**Proposed modification of the Tweed Sand Quarry (Da 152-6-2005 Mod 1) with regard to the proposed increase in heavy vehicle movements**

I refer to your email dated 12 April 2018 requesting Council to provide comment on the draft set of conditions for the Tweed Sand Quarry Mod 1 and traffic considerations associated with the proposed Mod. Please find below Council officer's comments:

Figure 2.5: Tweed Coast Road / Crescent Street Intersection Layout

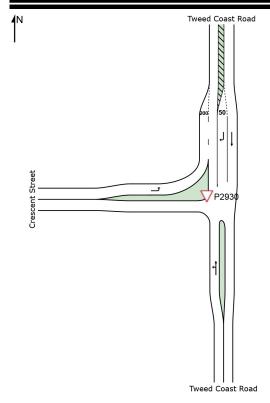
In addition, Council raises an objection to the requirement for the delayed construction of an acceleration lane on the north bound lane of Tweed Coast Road at its intersection with Crescent Street.

As previously discussed, Council has serious concerns with the upgrade being delayed until 2023 and consider that the construction should be undertaken prior to the increase in traffic volumes from the Tweed Sand Quarry.

The acceleration lane will enable heavy vehicles to merge onto the northbound traffic stream at around the posted 80km/h. The effectiveness of the upgrade to this intersection is related to the numbers of vehicles carrying out this manoeuvre and would improve the productivity of operations (as delays at the intersection would be reduced). An estimation of the cost for the treatment is in the order of \$250,000 to construct. The right turn treatment from Tweed Coast Road into Crescent Street requires changes to line marking only.

Without the north bound acceleration lane, there is the risk that heavy vehicles will enter the stream when inappropriate gaps are available leading to potential crashes and / or reduction of speeds on Tweed Coast Road, to accommodate the entering traffic. Austroads Guide to Road Design Part 4a advises that an auxiliary lane is provided for **safety and/or intersection capacity purposes**.

The Bitzios report advises that without the removal of the Crescent Street right turn movement, the Degree of Saturation at the intersection is above 0.8. Removal of the Crescent Street right turn reduces the DOS to 0.739 which is still of concern as it is approaching the 0.8 threshold which triggers an upgrade to the intersection.

As the local Roads Authority, Council previously has advised that the removal of the right turn movement from Crescent Street to Tweed Coast Road is not supported. Simply installing signs at this location banning the movement will result in non-compliance which would need to be addressed by Police. Installing physical devices to prohibit the movement would result in construction costs borne by Council, which is unacceptable.

Accordingly, it is considered appropriate that Condition 24 be modified such that any final agreement between Tweed Sand Quarry and Cudgen Lakes Sand Quarry (arranged prior to determination) be referenced in the condition and that the timing of the upgrade to the intersection of Tweed Coast Road and Crescent Street (i.e. constructing a northbound acceleration lane on Tweed Coast Road to the appropriate Austroads requirements) be prior to any increase in truck movements associated with Mod 1.

Figure 4.7: Altona Road Layout

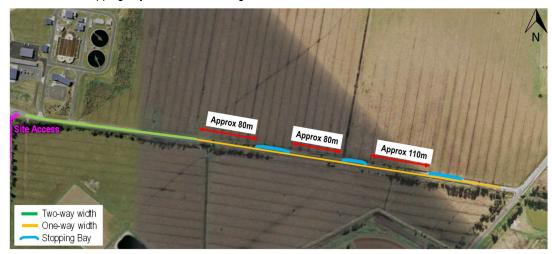
- (b) upgrade of the current alignment of Altona Road to include two additional passing bays, each having sufficient length to readily accommodate a laden quarry truck and dog; and*
- (c) maintenance of Altona Road.*

As previously noted, Council are happy to facilitate an agreement between parties for the upgrade and maintenance of Altona Road, but object to the requirement for such an agreement as a condition of consent. It is considered that the agreement needs to be reached prior to the determination of this application and then the Mod condition can make reference to the actual agreement.
